**WELWYN HATFIELD BOROUGH COUNCIL
EXECUTIVE DIRECTOR - PLANNING, PUBLIC PROTECTION AND GOVERNANCE**

Application No: 6/2018/1200/FULL
Location: Vertigo Adventures Stanborough Park North Stanborough Road
 Welwyn Garden City AL8 6DF
Proposal: Erection of a pagoda for use as a children's party tent
Officer: Ms Louise Sahlke

Recommendation: Refused

Drg. No VA1 (A3)

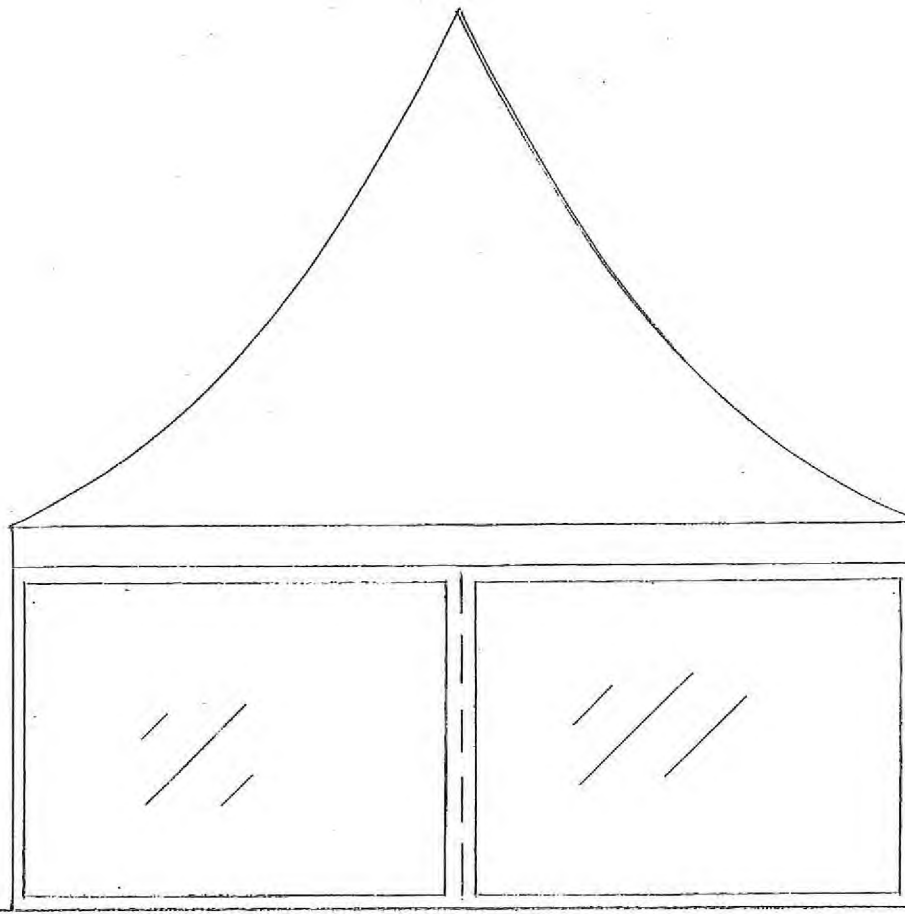
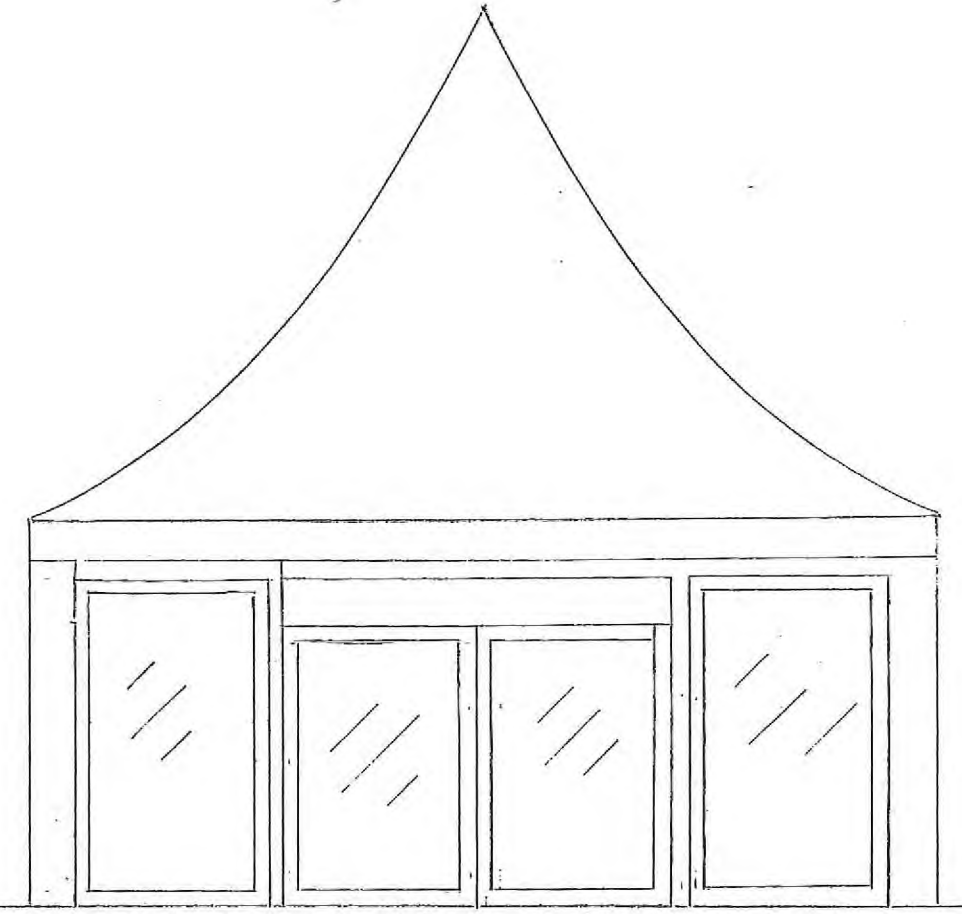
<p>The original floorspace of the Splashlands development was considered to be 1170sqm and the highest structure was 4 metres.</p> <p>The tent would be located to the north west of the high ropes adventure course facility. It is shown 10.5 metres in from the application boundary line. It would be 6 metres (width) by 6 metres (deep) with an eaves height of 2.5 metres and maximum ridge height of 5.9 metres.</p> <p>Due to its position, bulk, increased height above the original structures, massing, materials and level of permanence against a backdrop of predominantly light weight structures, it is considered that the proposed tent would appear prominent within its immediate setting to the high ropes adventure course facility and from wider views when viewed with the existing mature trees surrounding the site. Therefore the proposed tent would have an adverse impact on the openness of the Green Belt and the purposes of including this land within it contrary to the aims of the National Planning Policy Framework 2018, and local plan policies.</p> <p><i>Vitality and viability</i></p> <p>The proposed tent is a suitable outdoors use but given its use in relation to the high ropes adventure course facility would not be more suited to a location inside the two town centres of the Borough. Notwithstanding this it is located in close proximity to Welwyn Garden City, where it is not considered that it would adversely affect the vitality and viability of the centre given the nature of the use and that there are no other facilities similar to this within close proximity of the site. With regard to the remaining criteria of this policy, these are assessed in the sections below.</p> <p><i>Conclusion</i></p> <p>The tent would harm the openness of the Green Belt. As a result, the development fails to fall within an exception to Green Belt Policy representing an inappropriate form of development in the Green Belt, and substantial weight should be afforded to the harm to the green belt by virtue of inappropriateness, openness, as well as any other harm.</p>

<p>This has been discussed under the principle section of the delegated report and is considered contrary to planning policy.</p> <p>Notwithstanding this, the proposed tent would as a result of its siting, form and height be visible from the surrounding area. It is considered an obtrusive form of development which would fail to integrate within the existing landscape and would fail to preserve the openness and purposes of the Green Belt.</p> <p>With regard to the impact of the development on the visual amenities and character of the Green Belt, policies D1 and D2 of the District Plan 2005 are also relevant which aim to ensure a high quality of design and to ensure that development respects and relates to the character and context of the locality, maintaining and where possible enhancing the character of the existing area.</p> <p>The proposed development would be visible from a number of locations around the site which are publicly accessible, including public rights of way and the mound to the north of the application site where views down onto the development will be available. The proposed tent would be located on the lower land levels and would be adjacent to the landscape along the River Lea. This stretch of the park has several tall trees which range from 12m to 18m in height. The tent would be 4 metres which is lower in height than the abseiling tower at 13m which is broadly the same height as the surrounding trees. Based on height alone, the tent could integrate appropriately with the surrounding trees and landscape. However the tent does not blend into the landscape due to the use of inappropriate materials, which are not in keeping with other buildings and structures on site.</p> <p>The tent would not be of the quality of design that the District Plan strives for in its policies. The tent does not reflect the nature of or the character of the area. Considering that there are no immediate plans to replace the tent with a better quality structure, and the need for the tent is not detailed as temporary, it is considered that the poor quality design is not overcome by the temporary time period of the permission sought. Whilst the siting of the tent is such that it is only discernible from spaces within the wider site (Stanborough Park), it is maintained that the tent would be an incongruous addition to the area which would detract from the character of the site.</p> <p>In conclusion, the proposed development would fail to comply with the NPPF 2018 and Policies CLT2, D1, D2, RA10 and RA21 of the District Plan 2005.</p>

2. In regards to any other harm, the proposed tent would be of poor quality design harming the character and the appearance of the site that would not be made more acceptable by the request for its temporary siting only. The substantial weight afforded to these harmful elements is not clearly outweighed by the cumulative 'very special circumstances' applicable. The proposal therefore fails to accord with the National Planning Policy Framework 2018, policies D1, D2, RA10, RA21 CLT2, CLT3, and GBSP1 of the District Plan 2005, and the Supplementary Design Guidance Statement of Council Policy 2005.

BLOCK PLAN

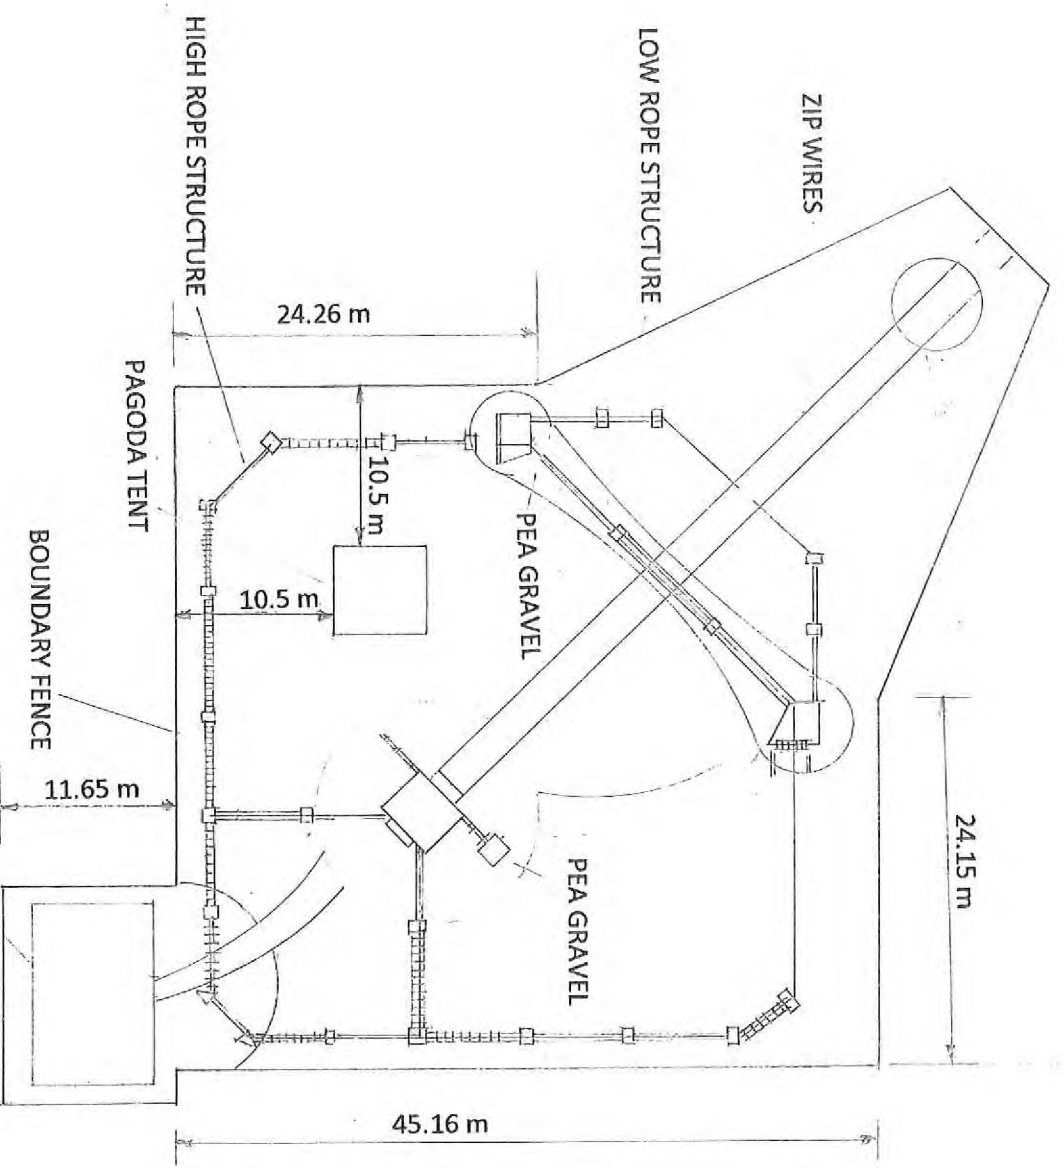
Ecology	<p>The proposed tent due to the nature of the development is not considered to impact on local ecology.</p>
Flood Risk Assessment	<p>The proposed development appears to sit within Flood Zone 2 and Flood Zone 3 and 3b within the red line boundary of the site.</p> <p>The Local Planning Authority have viewed the Environment Agency's standing advice before making a decision on this application.</p> <p>This advice states that a Flood Risk Assessment (FRA) should be included in the application. While the Planning Statement dated April 2018 refers to a FRA, one has not been submitted in support of this application.</p> <p>The applicant considers that a full FRA has been undertaken as part of the Splashlands Development. Therefore is not required for this planning application. However the tent was not included as part of this application and therefore it is considered that a FRA should be included to determine the flood risk. Therefore the proposal is contrary to the National Planning Policy Framework 2018, Policy R7 of the District Plan 2005.</p>

3. The planning application is not supported by a Flood Risk Assessment that demonstrates the developments suitability for its location within Flood Zones 2 and 3 and therefore is contrary to the National Planning Policy Framework 2018 and Policy R7 of the District Plan 2005.
